***Planning Department
Transportation Development Services***

March 10, 2015

Re: Pasadena Office Warehouse
5656 Pasadena NE
Traffic Circulation Layout
Engineer's/Architect's Stamp dated 7/14/14 (B18-D019)

PROPOSED SITE PLAN

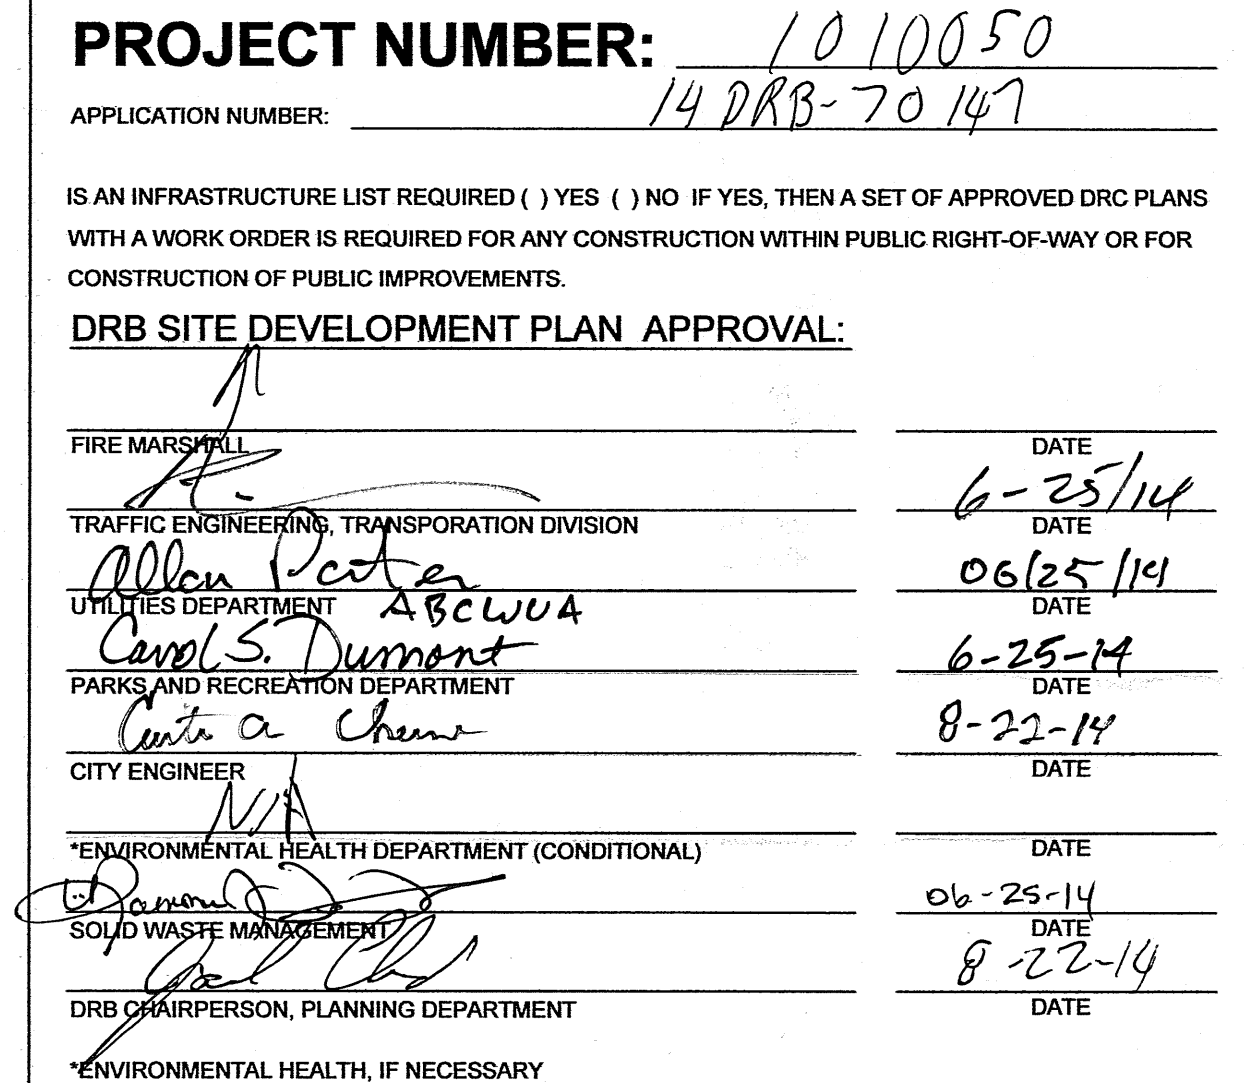
1. Please include written letter of Transportation Certification.
2. The handicap accessible spaces must include an 8-foot wide van access aisle; all other aisles should be 5 feet in width. The van accessible aisle must not be blocked in any way. Upon inspection, there were two bollards at the front end of van accessible aisle.

3. The ADA van accessible sign must have the required language per 66-7-352.4C NMSA 1978 "**Violators Are Subject to a Fine and/or Towing.**"
4. Per the DPM, a 6 ft. wide ADA accessible pedestrian pathway is required from the public sidewalk to the building entrances. Upon inspection, this pathway is not provided. There is a stepped walkway from the public sidewalk to the building entrance. See picture below:
